PBRA / JW
30 November 2011

Planning Application ref: P/07/11
New House at 52 East Front Road, Pagham
Letter of Objection

Project	52 EAST FRONT ROAD, PAGHAM, BOGNOR REGIS WEST SUSSEX PO21 4ST	Drawn	sk	Project	126
For	Mr and Mrs Eysers	Scale	1:100 @ A3		
Title	GROUND FLOOR - PROPOSED	Date	25.10.2011	Revision	d
				Drawing No.	P 01

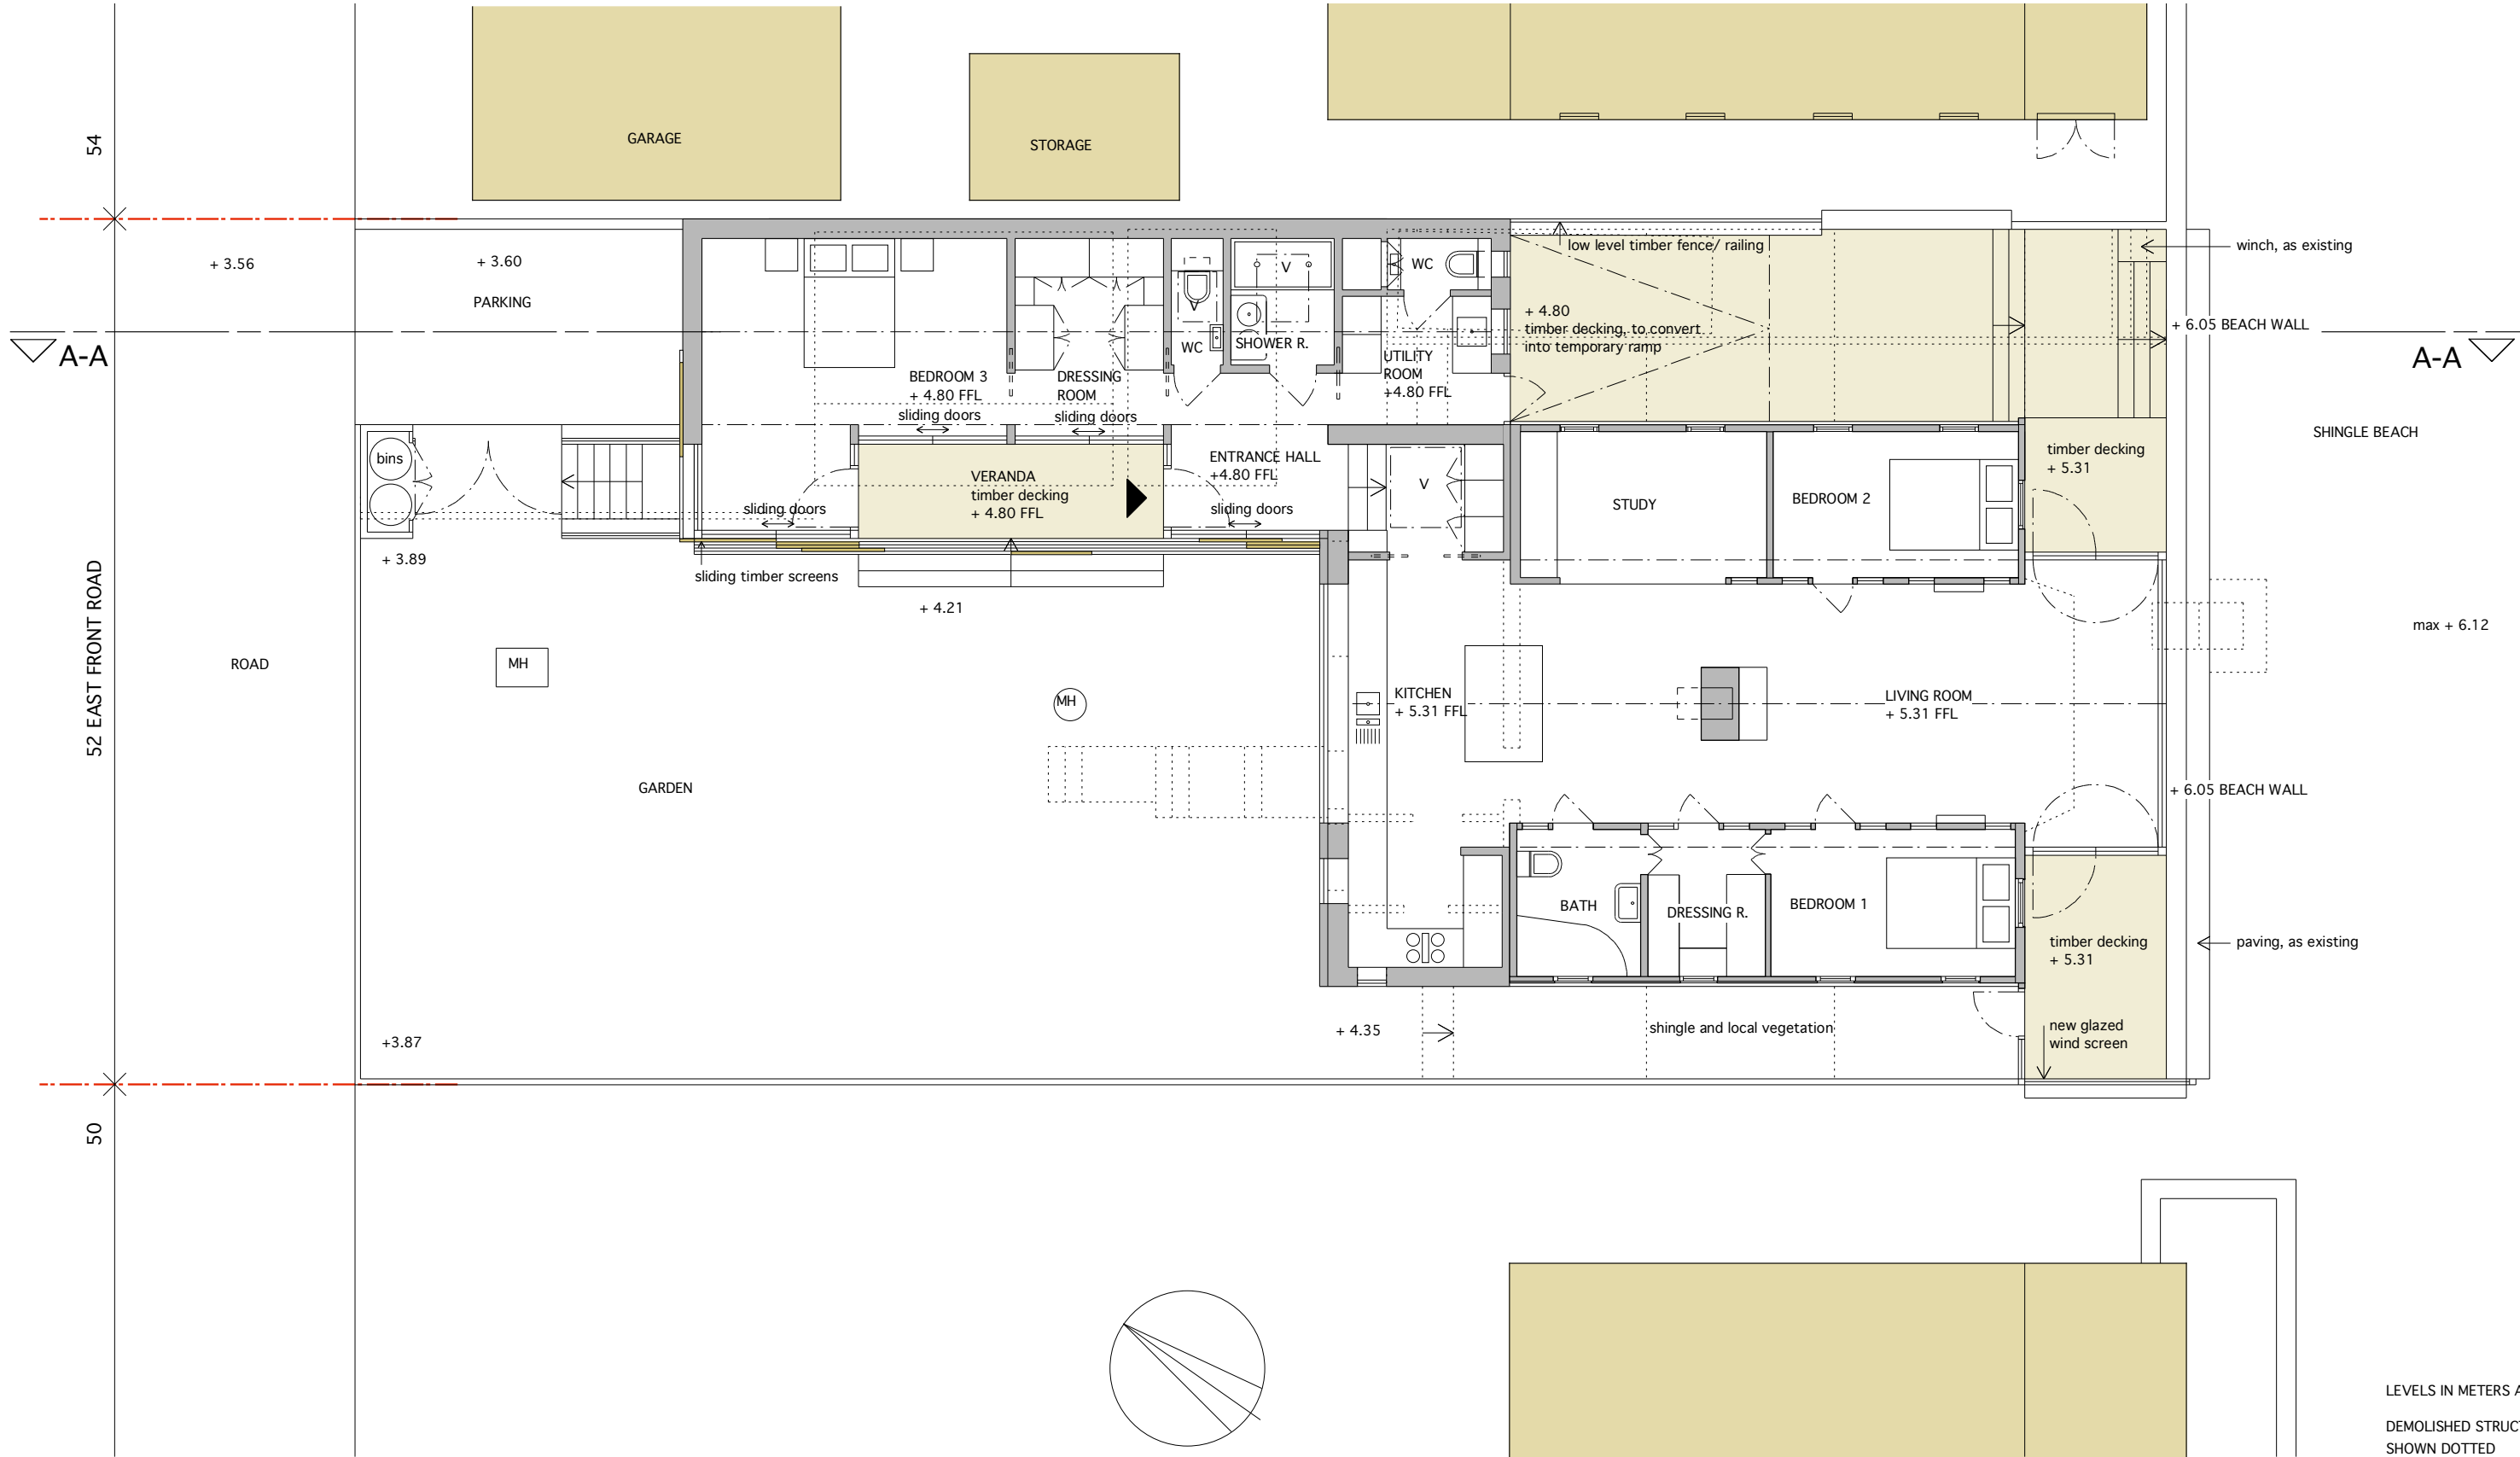
1. **The extension to the house lies ~~on~~ on the boundary to the adjoining property,** where development on adjacent sites on the Beach Estate usually allows approximately 1m clearance from the boundary to avoid shading and overcroding as well as allowing the property to be maintained from the owners land
2. **The extension is a two storey construction whereas the Village Design Statement prescribes a single storey limit on development.** Although this ~~is~~ ~~is~~ requirement has been transgressed in the past this is damaging to the Estate and should be resisted at all costs.
3. **The 'undercroft' below the extension implies a dangerous and potentially damaging construction sequence.** The angle of repose of the beach shingle is typically 30° so the excavation to form this would inevitably cause the collapse of surrounding structures.
